Recommendation Report for Planning Permission for Works or Extension to a Dwelling

REF NO: LU/261/15/HH

LOCATION: 10 Mariners Quay
River Road
Littlehampton

PROPOSAL: Single storey ground floor extension to northern elevation of dwelling; fenestration alterations to the southern elevation to include installation of bi-fold doors at ground floor and first floor level; and the addition of 4 No. roof lights. This application may be determined by LTC under delegated powers.

REAR ELEVATION

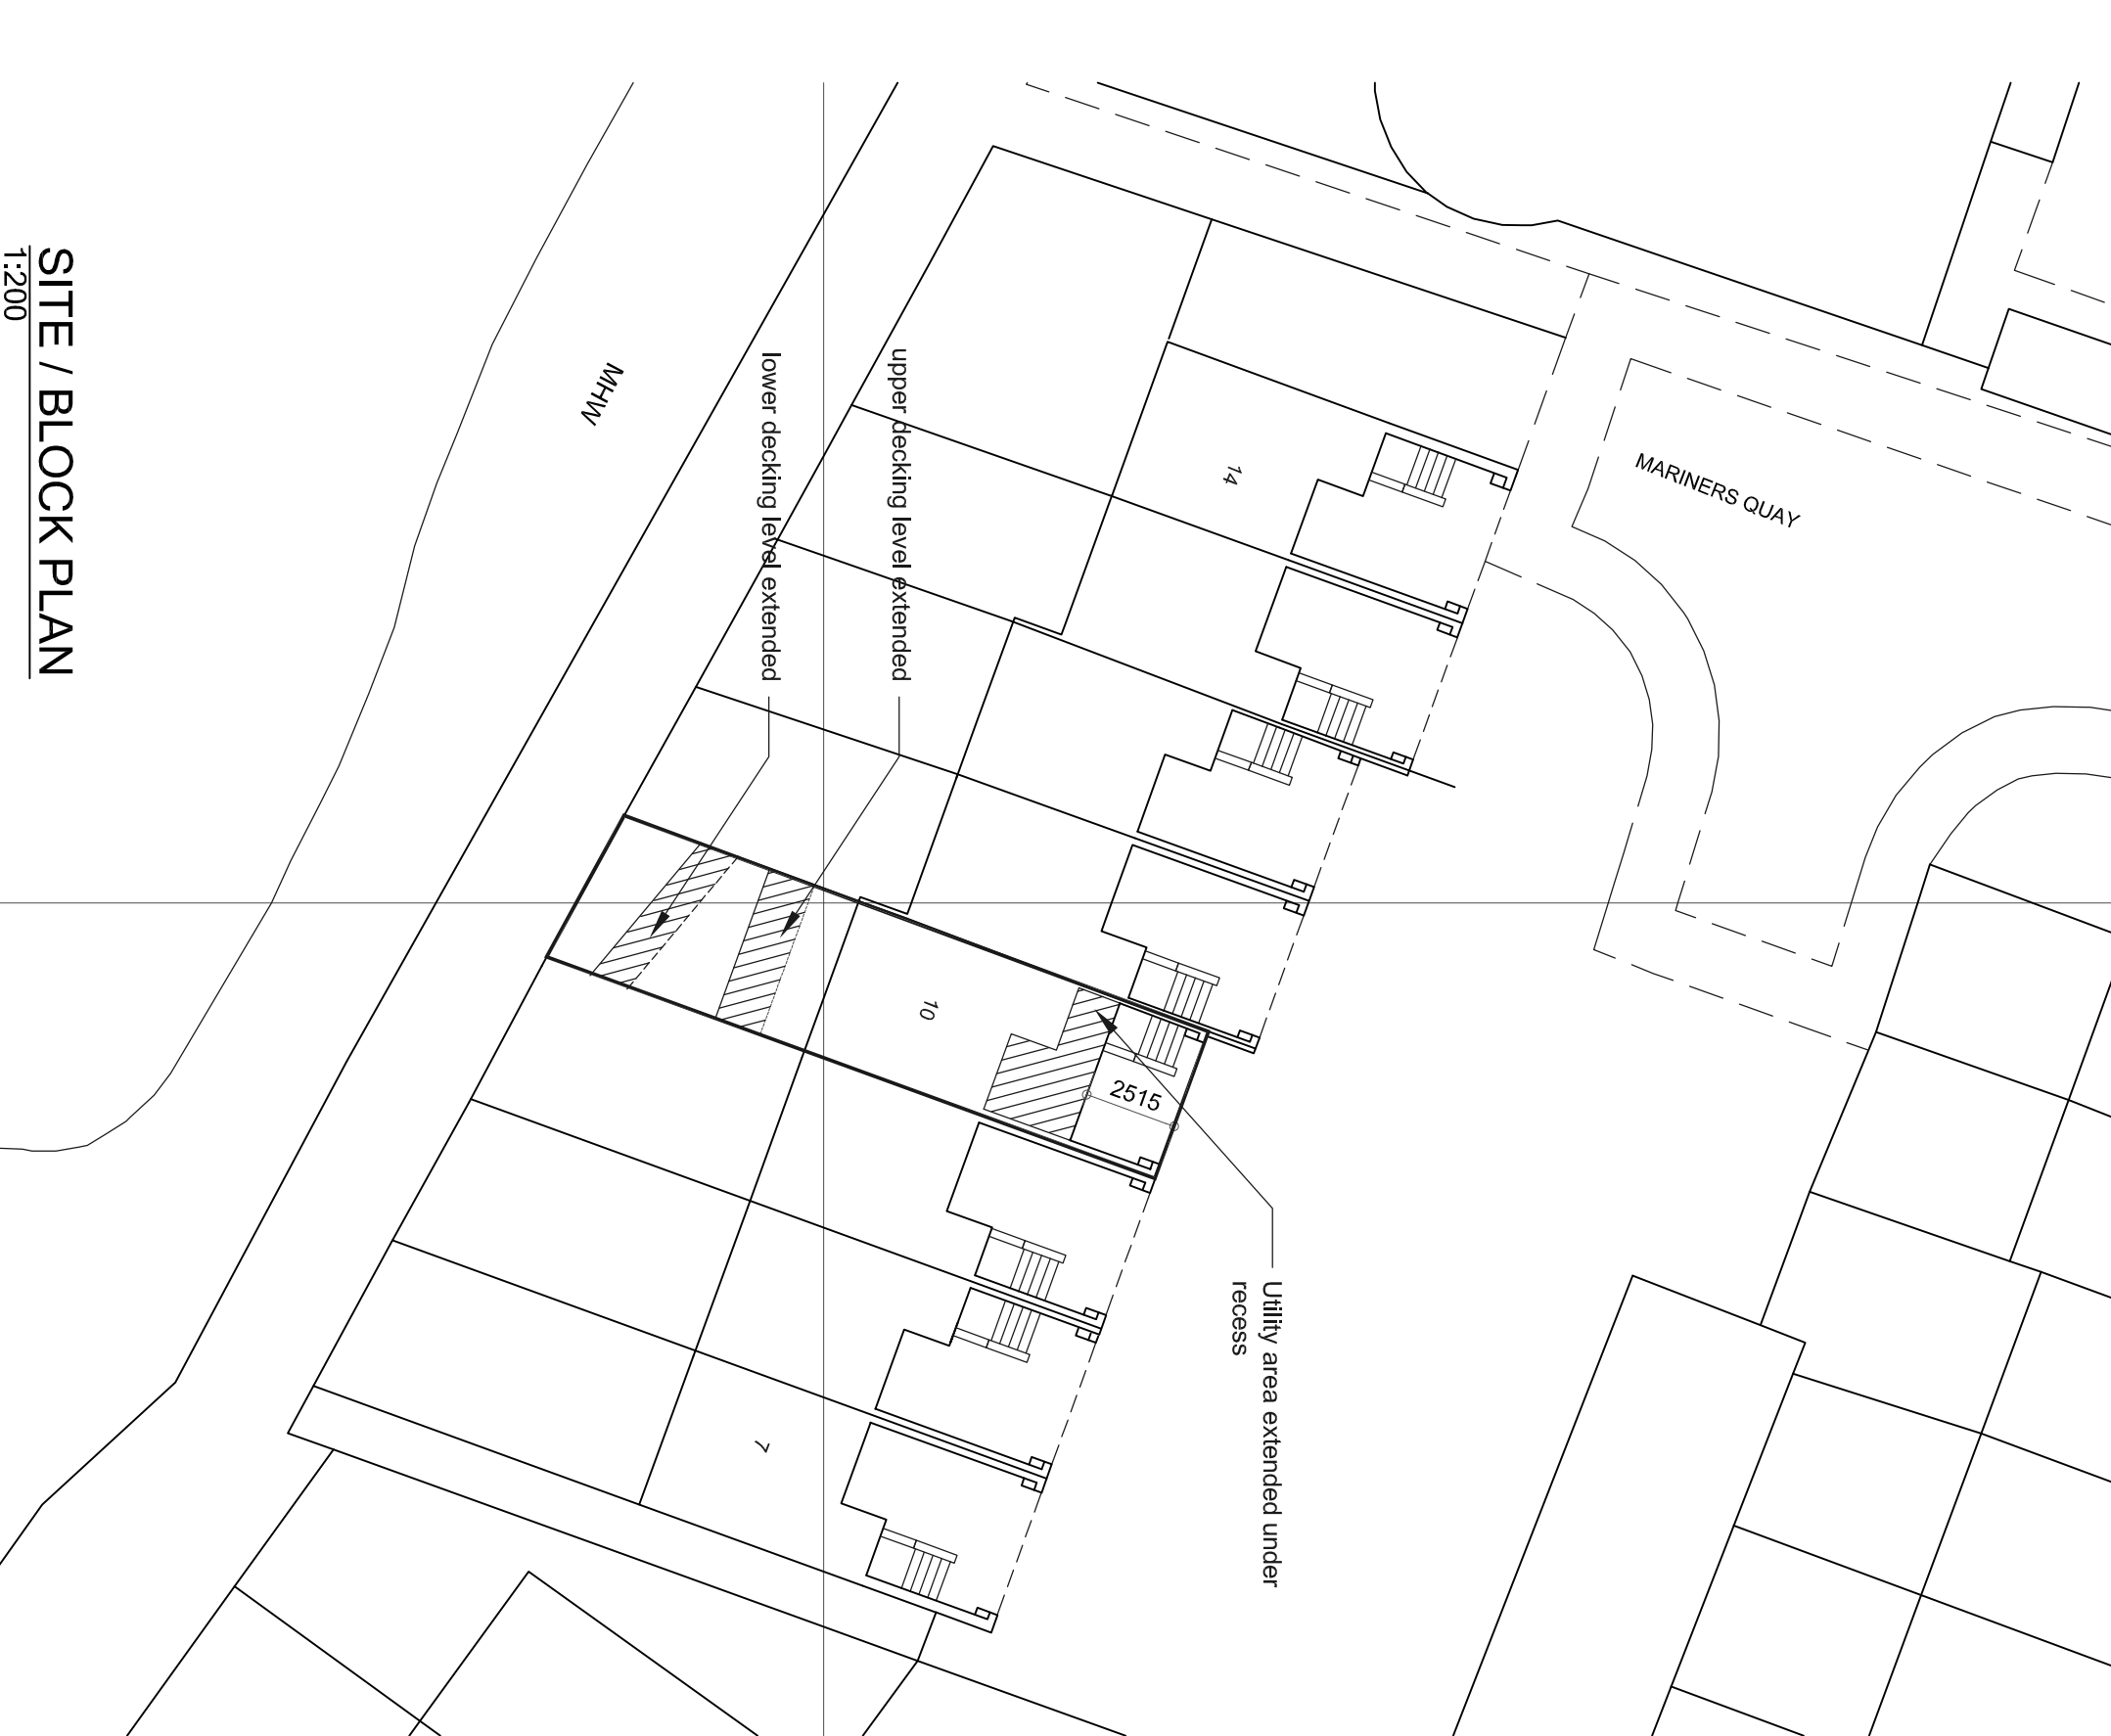
It is intended at first floor level for the existing door and window to be replaced by bi-fold doors. This aspect of the proposal is not considered to detrimentally impact upon the character and appearance of the dwelling. There are numerous examples of similar works having been carried out on the adjoining properties and therefore the alterations at first floor level are considered to be in accordance with policy GEN7(ii) of the Arun District Local Plan and policy D DM4 of the Emerging Local Plan.

THIRD FLOOR PLAN

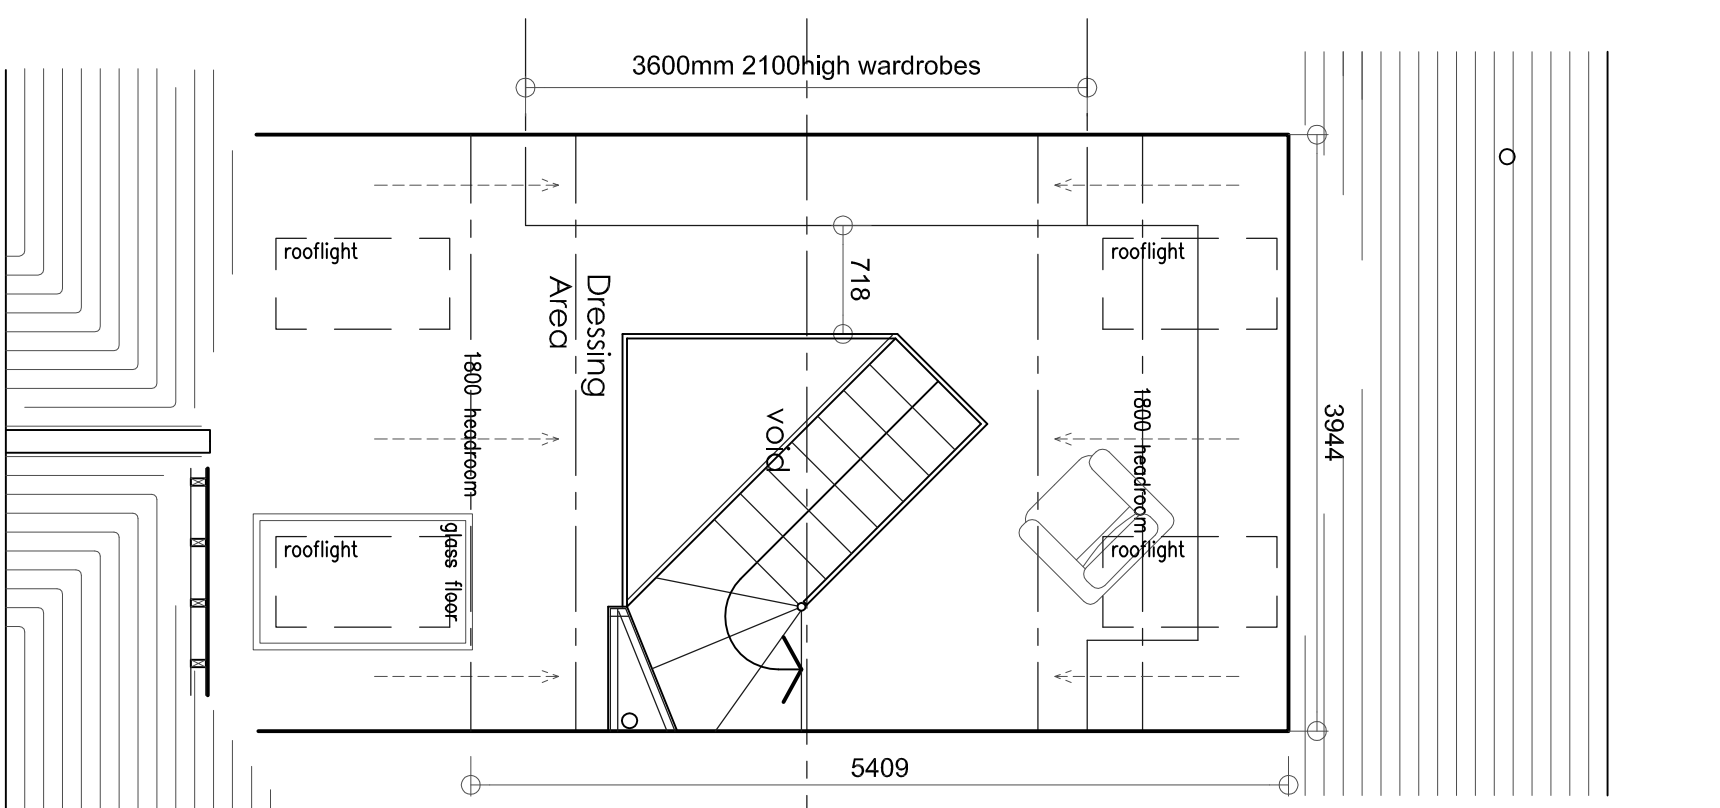
It is also proposed that 4 No. roof lights will be installed at the property (2 on the northern and 2 on the southern elevation). Roof lights are not an overly dominant feature within the locality of this site. However, given that they will not be visible from the riverside walkway or overly dominant when the property is viewed from the west bank of the river Arun, it is considered that the proposed alteration would be in accordance with policy GEN7(ii) Arun District Local Plan and D DM4 of the Emerging Local Plan.
